PORTLAND MAINE

December 20, 2010

RE: Bayside Bowl

It was a pleasure meeting with you and Justin recently to discuss plans for the outdoor expansion of Bayside Bowl. After reviewing the concept plan presented at our meeting, I have generated some preliminary staff comments that you may find helpful in preparing a formal development application submission.

FD.1
Level 1 Site
Plan Alteration

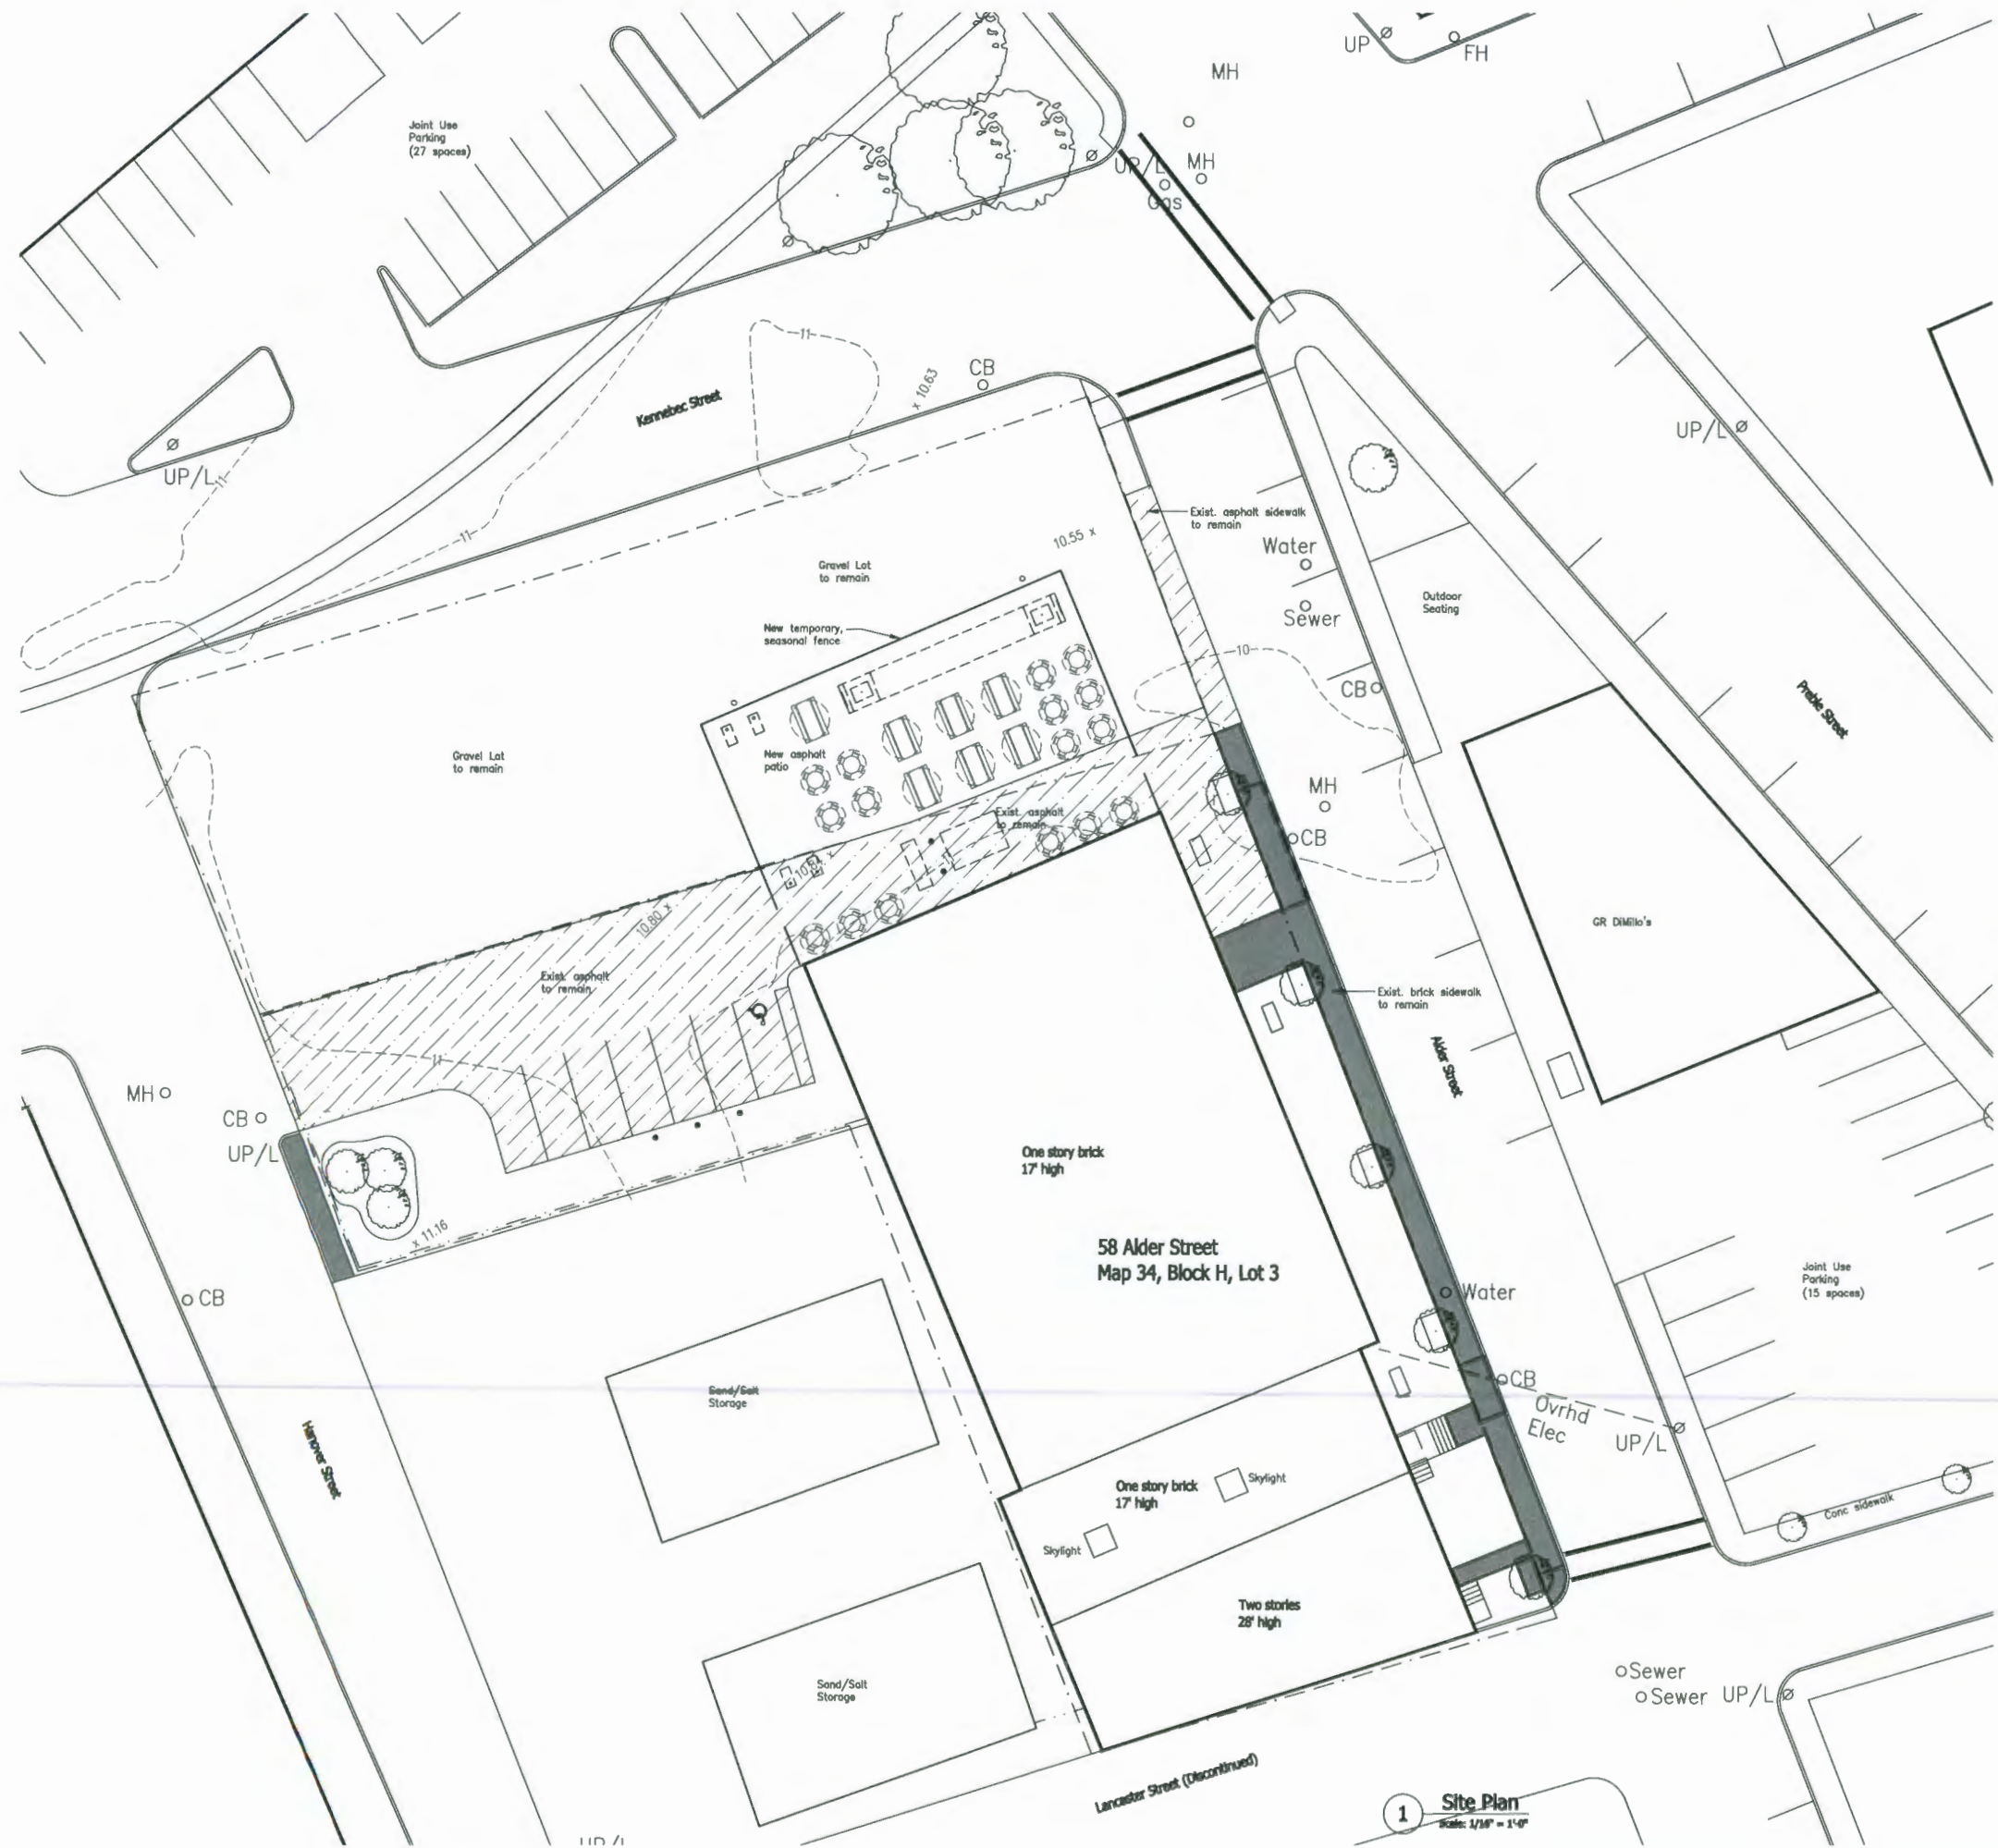
5. What is the ground surface of the outdoor facility? Will the site be regraded and if so, how will it affect drainage?
6. The property is a separate lot from the existing facility so new curb and sidewalk will be required along the property's street frontage on Alder Street and Hanover Street. The street frontage along Kennebec Street is likely to be discontinued under a proposed re-alignment of Kennebec Street and Somerset Street. In lieu of installing sidewalk and curb along Kennebec Street, it may make sense to require a financial contribution to the re-alignment (in the amount of the curb and sidewalk) for the City to install later.

7. I noticed there are new parking spaces shown on the plan. Under the existing ordinance, new surface parking is not allowed within 35 feet of the street. New parking more than 35 feet from the street requires Planning Board conditional use review. We are working on some new zoning revisions that would allow parking more than 35 feet from the street as a permitted use.

8. The proposed 6 foot high fence seems high. In the context of Bayside the design of the fence will be important.
